Consultation Response from KC, Conservation & Design
2023/92633 St Marys Rc Church, Upton Street, Carlinghow, Batley, WF17 8PH
Demolition of buildings and erection of residential development (within a Conservation Area)
Date Responded: 12.4.2024
Responding Officer: Sue Brooks
Responding Ref: BHS 4/15

This response should be read in conjunction with the associated listed building consent application 2023/92634.

Typical Ground Floor Plan

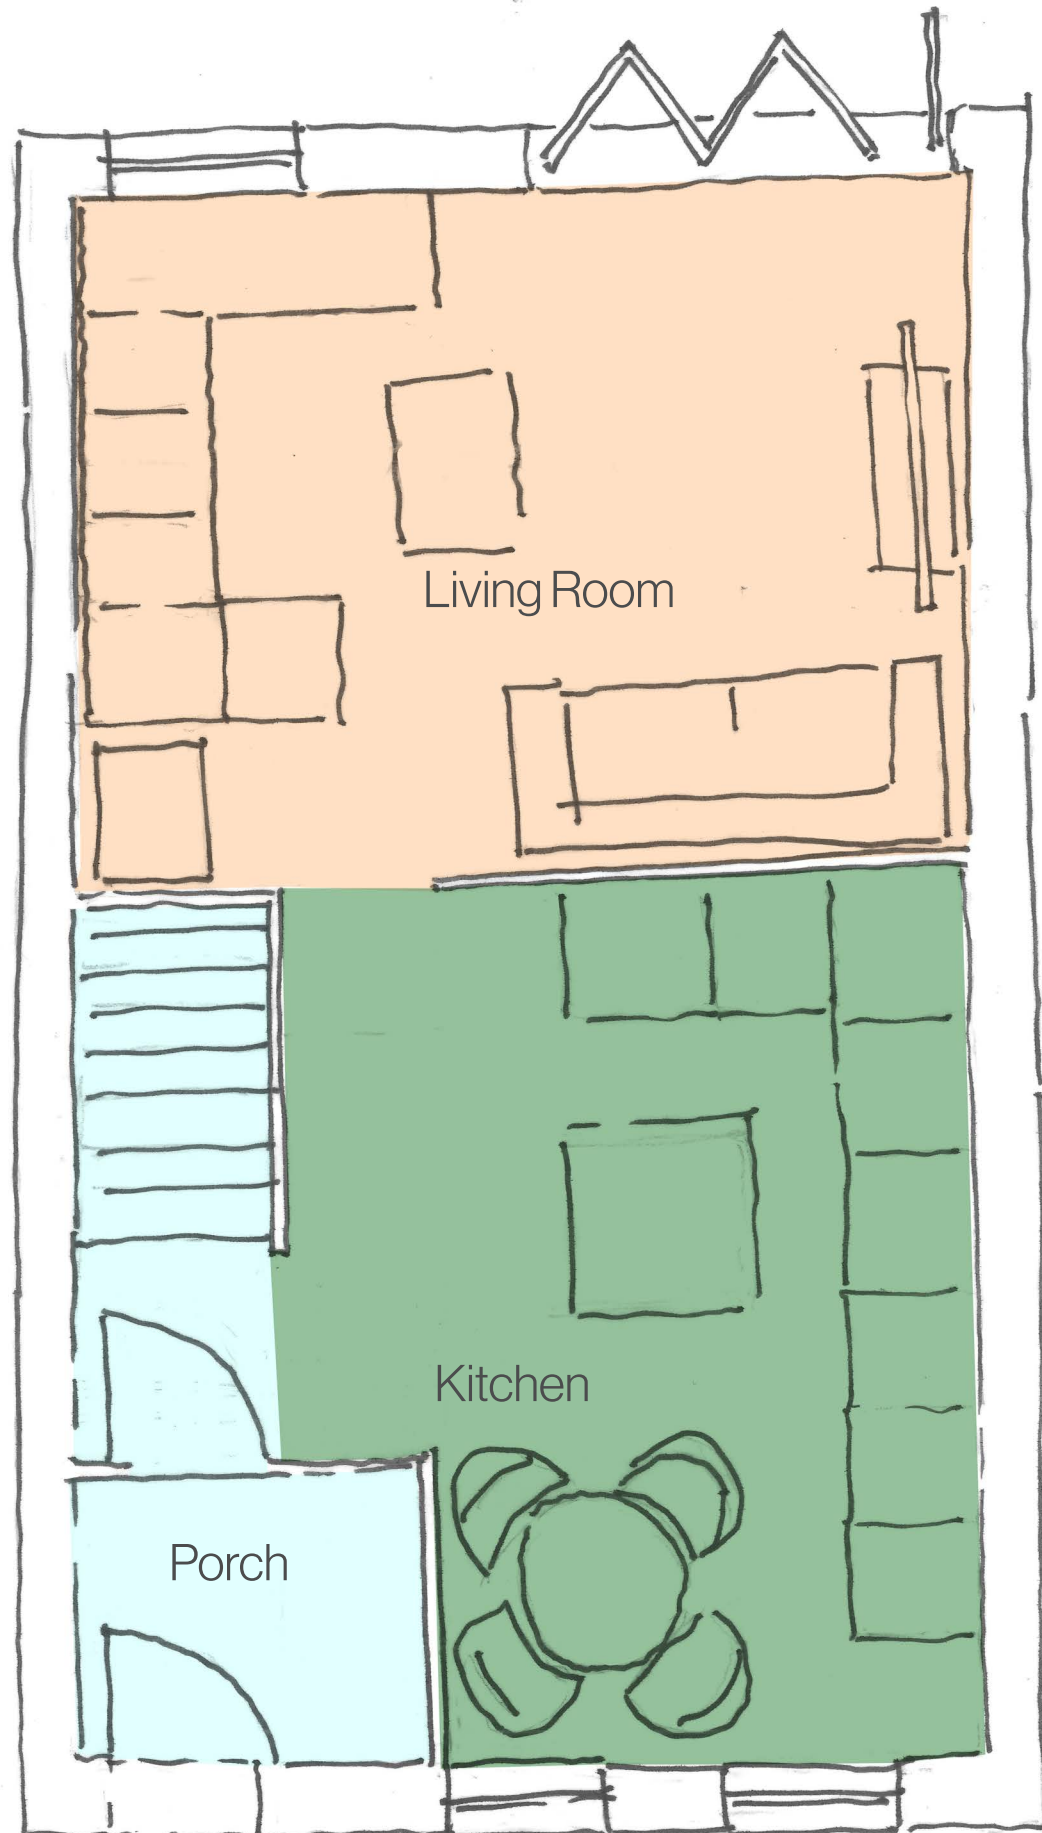
- Design – we would recommend that the design is revisited in line with the requirements of the policies above. References could be taken from the existing buildings on the site, with the use of natural stone and blue slate, and perhaps with architectural detailing reminiscent of the school extension, including small dormers or gables. The design of the Upton Street elevations appear secondary and we would recommend that the nunnery is retained, with the potential for new dwellings adjacent to this in place on the former houses on the site.

- UPVC windows - The Design document states that the window types aim to establish a sense of visual continuity, ensuring that the new residences harmoniously blend with the architectural heritage of the area, and it references design details and elements that are not shown on the proposed drawings or specified in the application form. We do not consider the proposed window design to respect the local context and would recommend that timber windows are specified in a traditional design, taking references from local characteristics.

- Bin stores and parking spaces to the front of the properties – these should be located to the rear so that the more attractive elevations face the cemetery. We would suggest that coursed natural stone from the demolition (if justified) is used for low boundary walls on the south and west boundaries to reflect the local character.
- The Climate Change Statement specifies solar panels on the roofs of all properties. No details have been submitted and the south pitches are highly prominent, facing the cemetery, and therefore this should be omitted.

Typical First Floor Plan

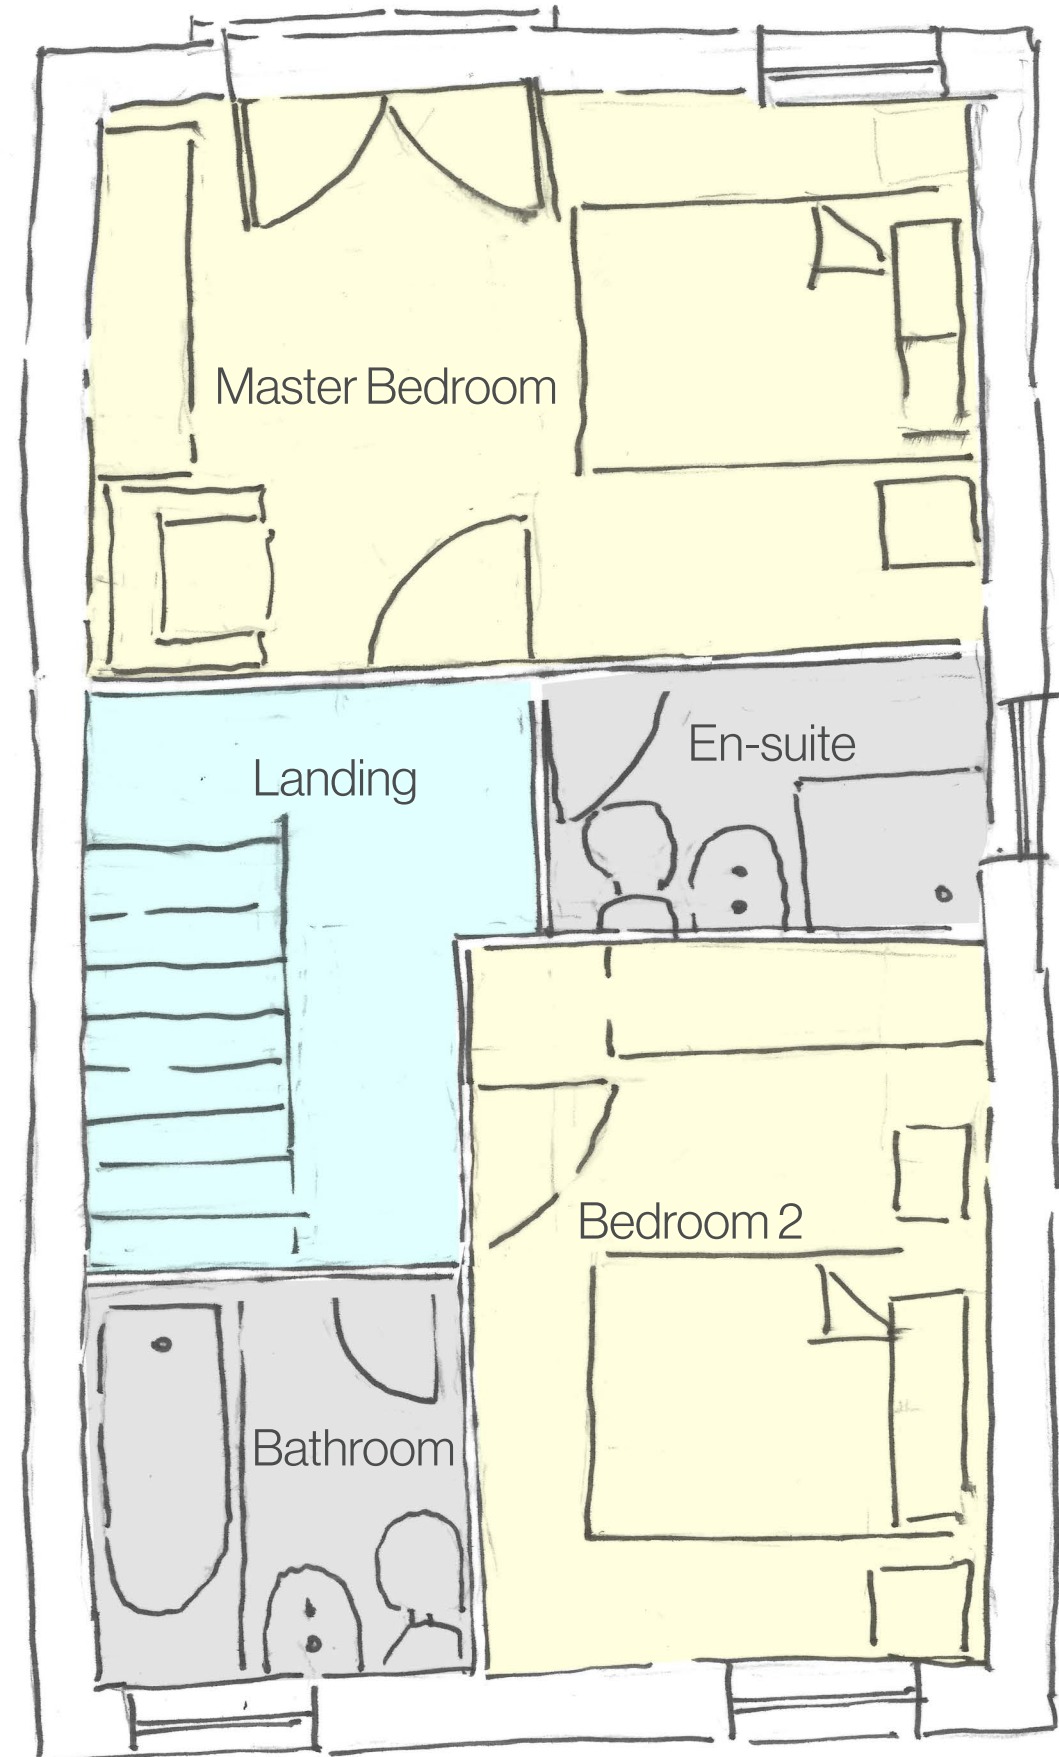
- External masonry - the proposed buff brick with brick detailing is not characteristic of the conservation area, and we would recommend natural coursed stone is specified with traditional detailing.

- Timber doors – these are acceptable subject to design – this can be a condition.
- Roofs - artificial grey slates are specified in the application form, whereas the design document refers to a blue tinted roof covering and a copper finish. Blue slate would be more characteristic of the site and wider conservation area and existing buildings on the site.
